Our Ref: 405062_LEO_023a

REVIEW OF SUBMISSIONS – APPLICATION # 05_0174 PROPOSED DREDGING OF OYSTER LEASE AND OPERATION OF SAND STOCKPILE – OYSTER LEASE # 80-178 AND LOTS 59, 101, 123, 124, 125 DP 753207, LOT 12 DP 816473, 2 – 6 RODMAY ST, TUNCURRY

1. Agency Comments Review

A.1 Site Plan - Dredging and Processing Sites

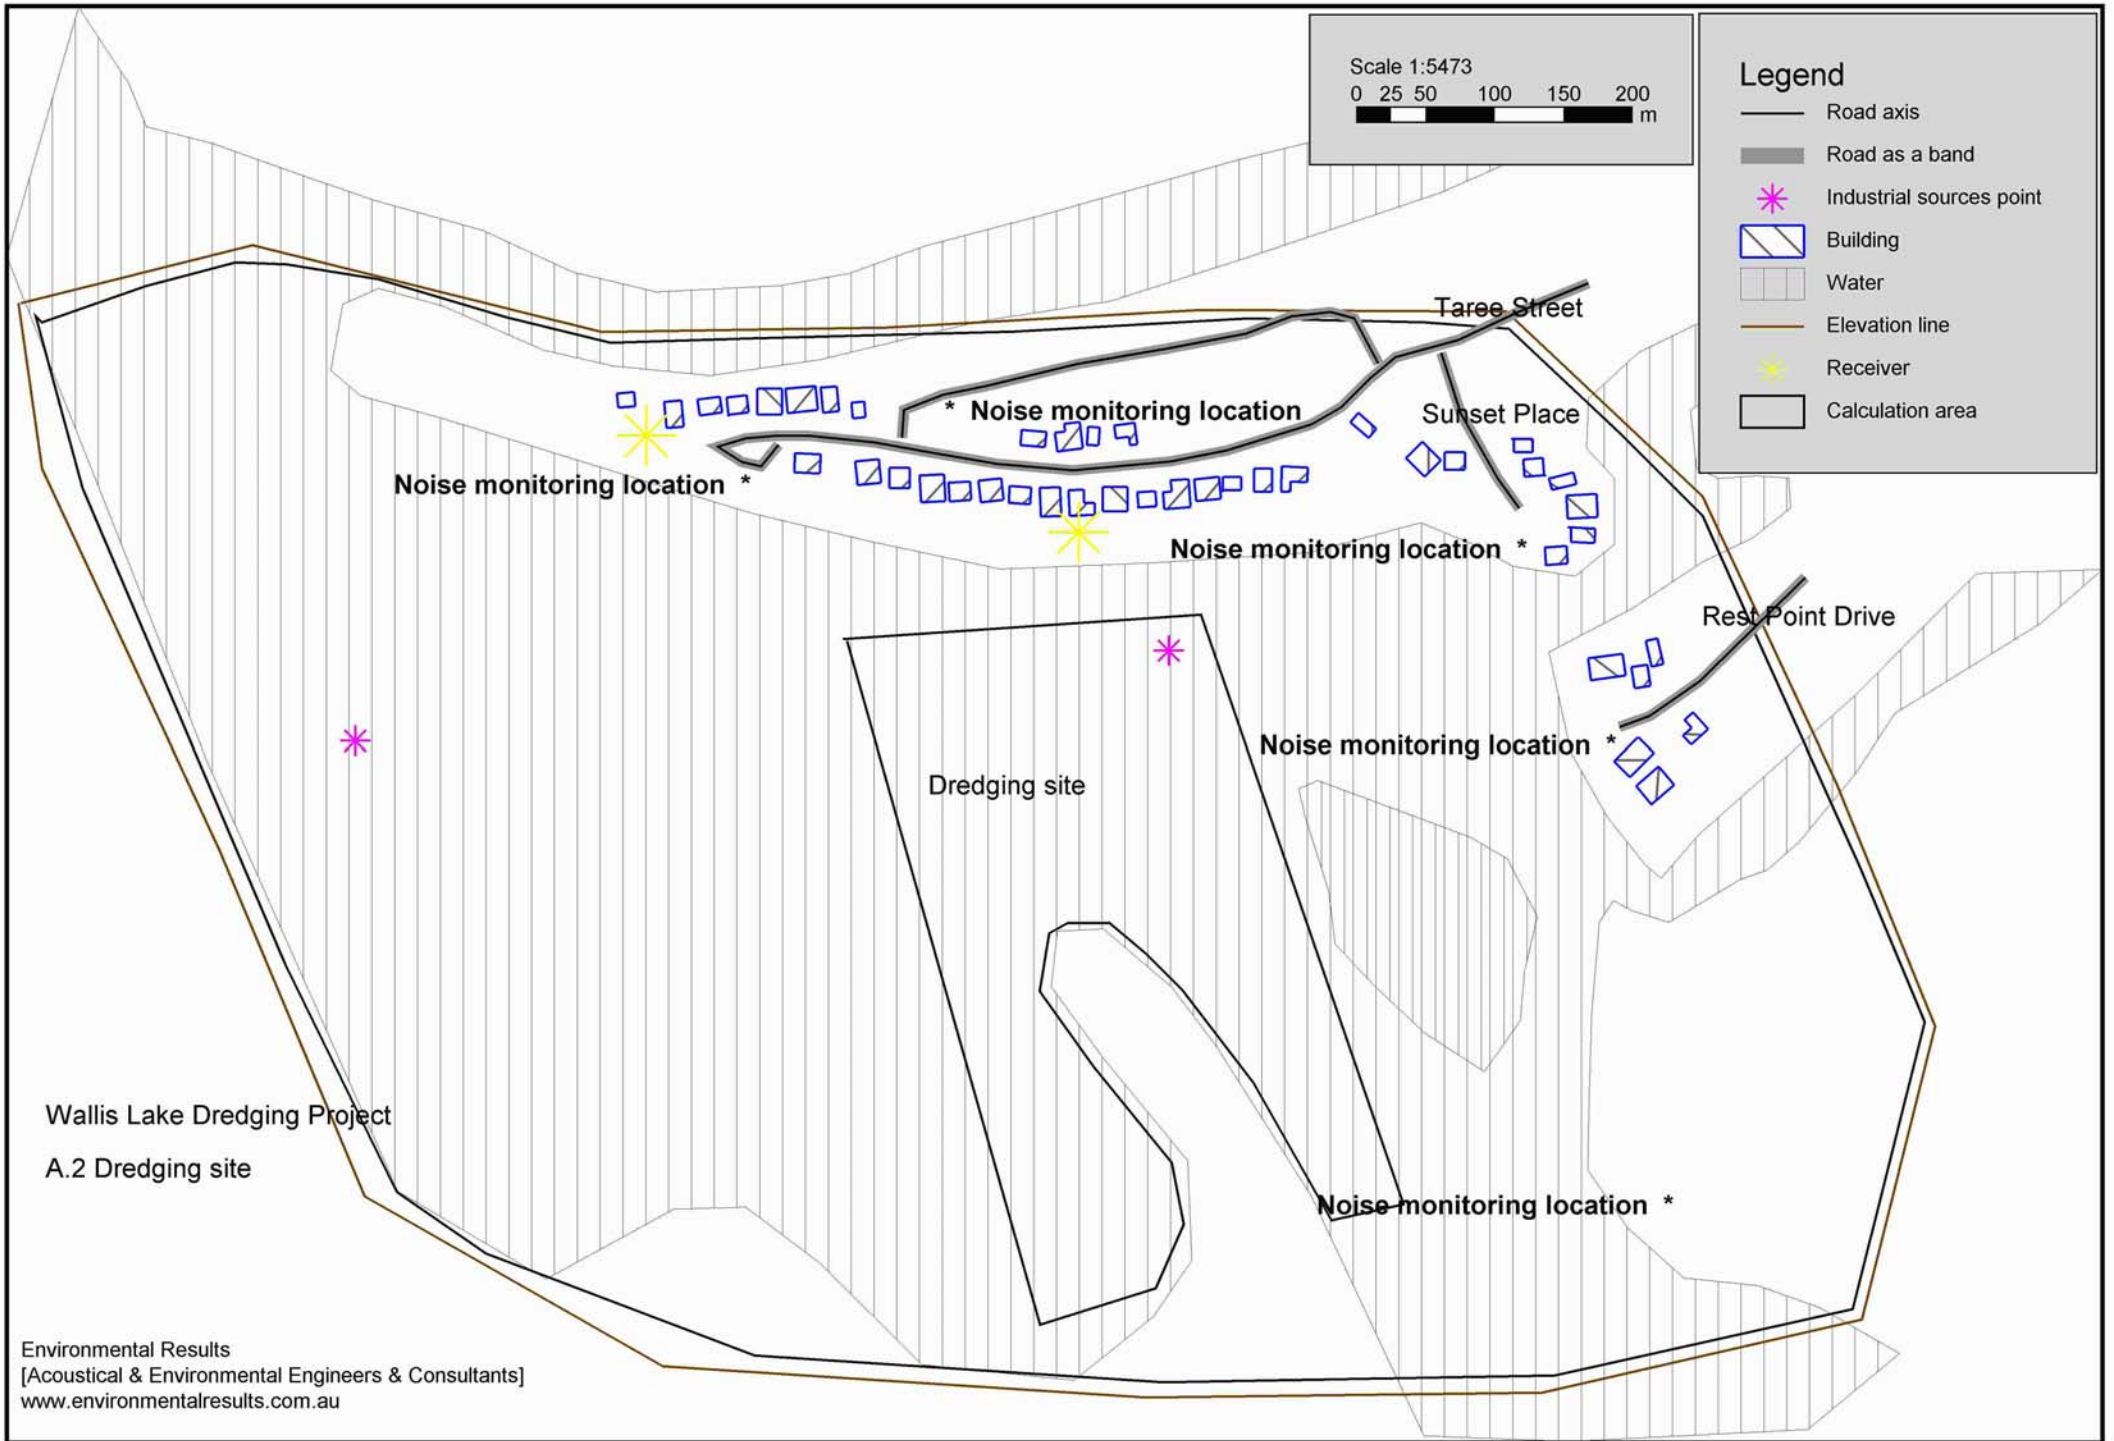
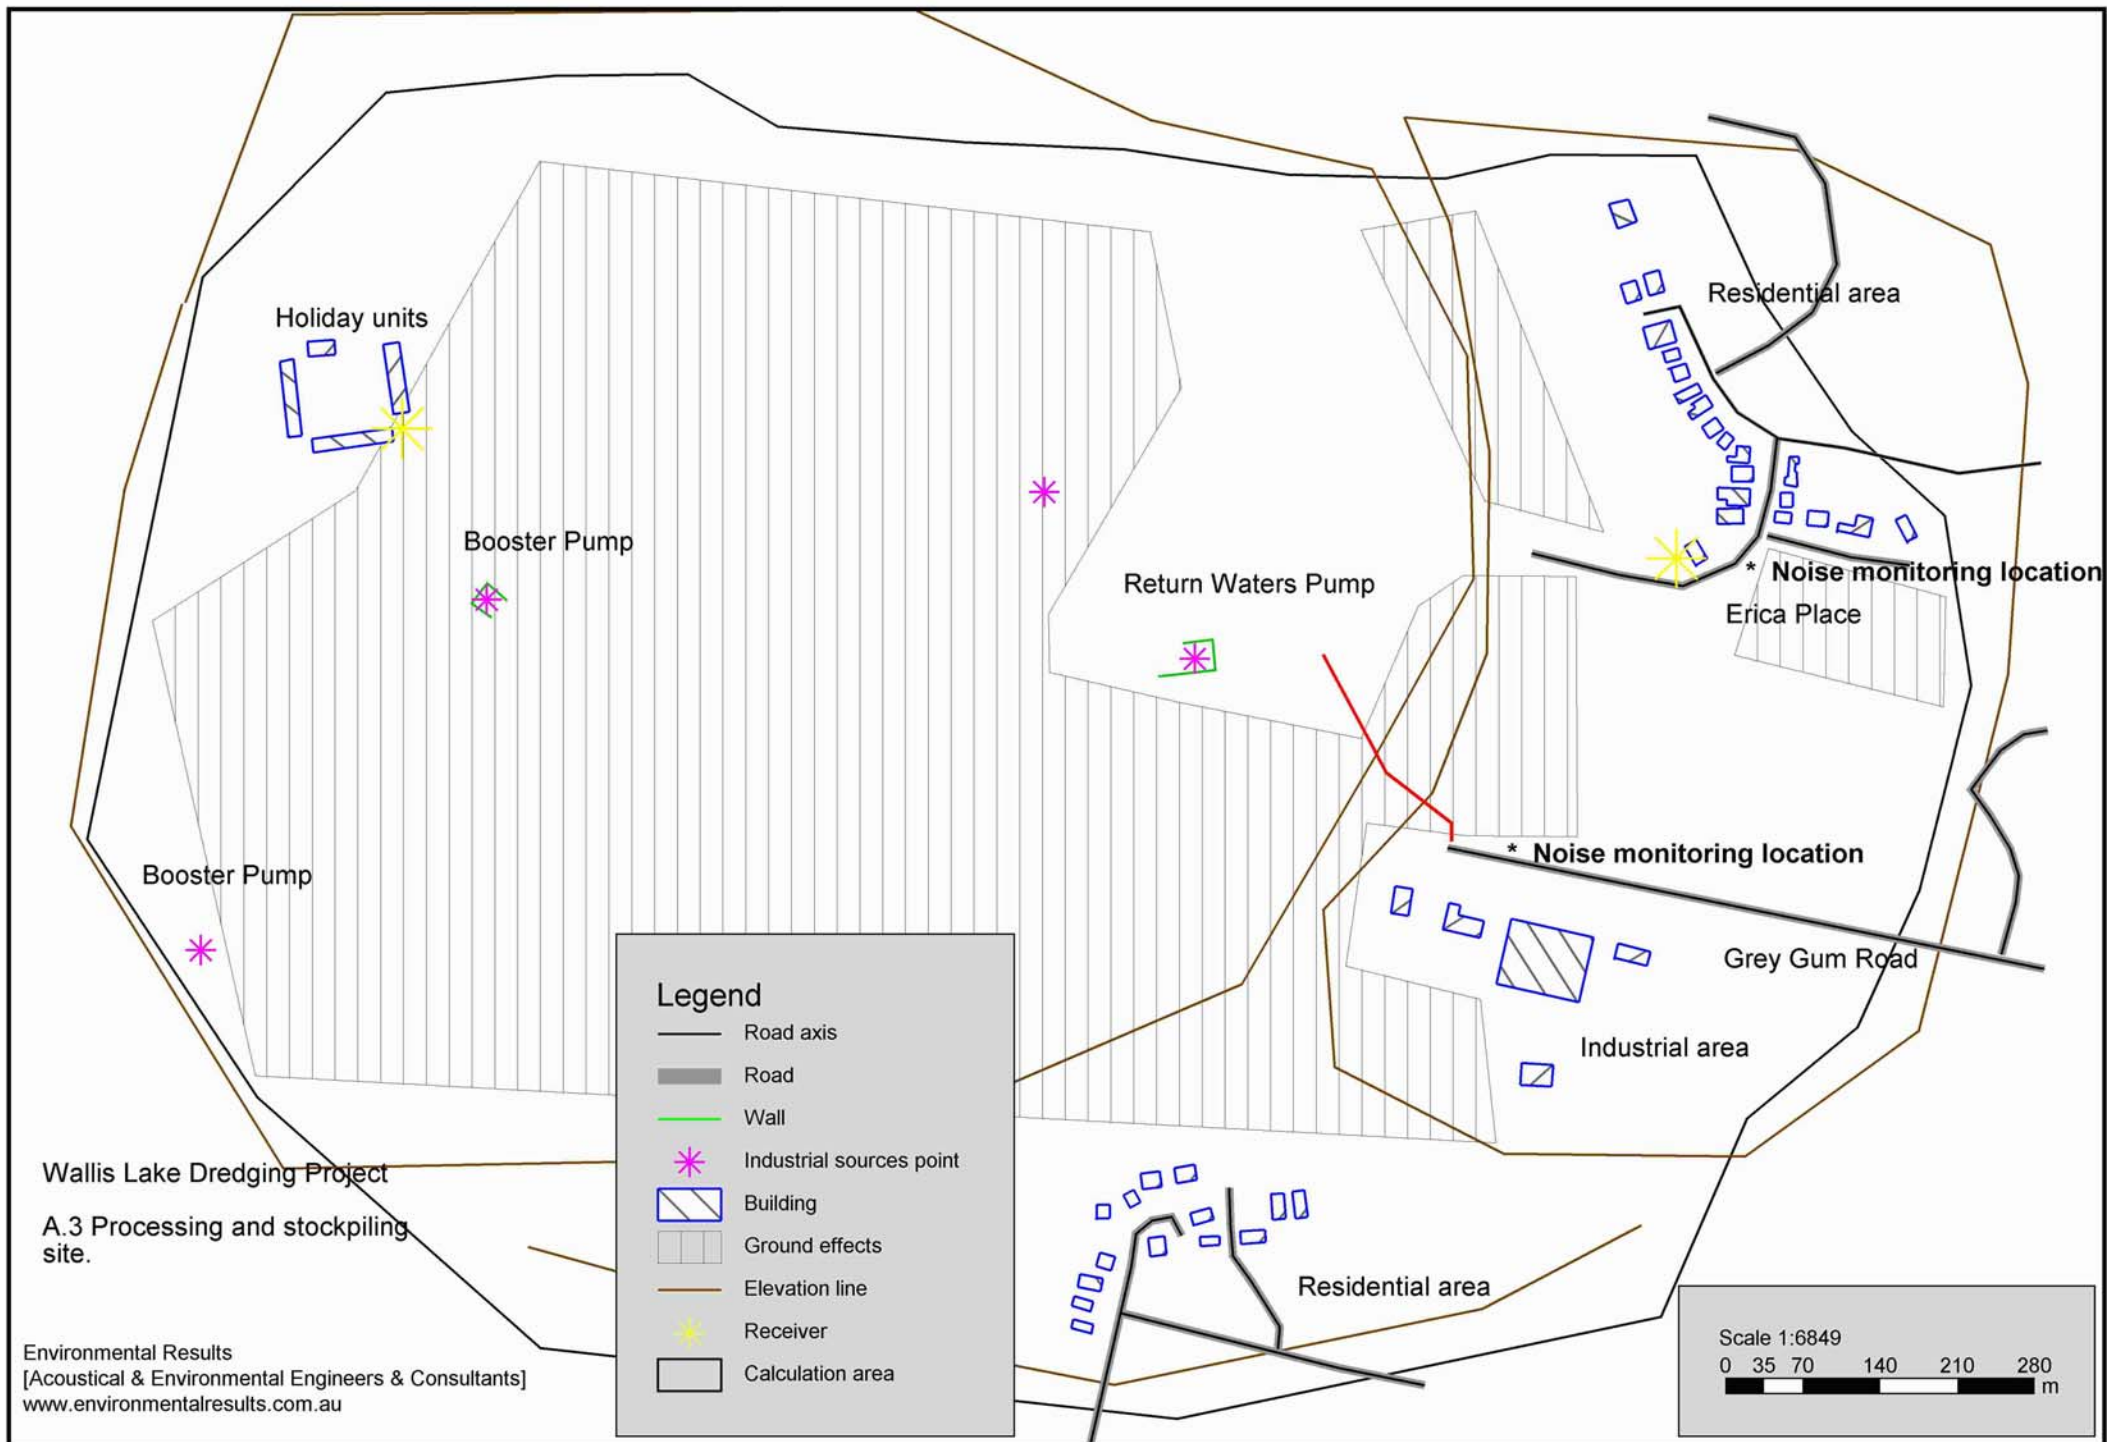
Figure 1.4 incorrect with respect to land status.

The figure will be amended to show the Crown road reserves (refer to attachment). The location of the pipeline, booster pumps and return waters pipeline will not be on the Crown road reserves. The pipeline will, however, be required to cross the Crown road reserves at two locations shown in the attached figure. Note that these road reserves are not used by the public (therefore there are no issues with respect to impediment to access) and are the subject of ongoing permissive occupancies held by the landowner.
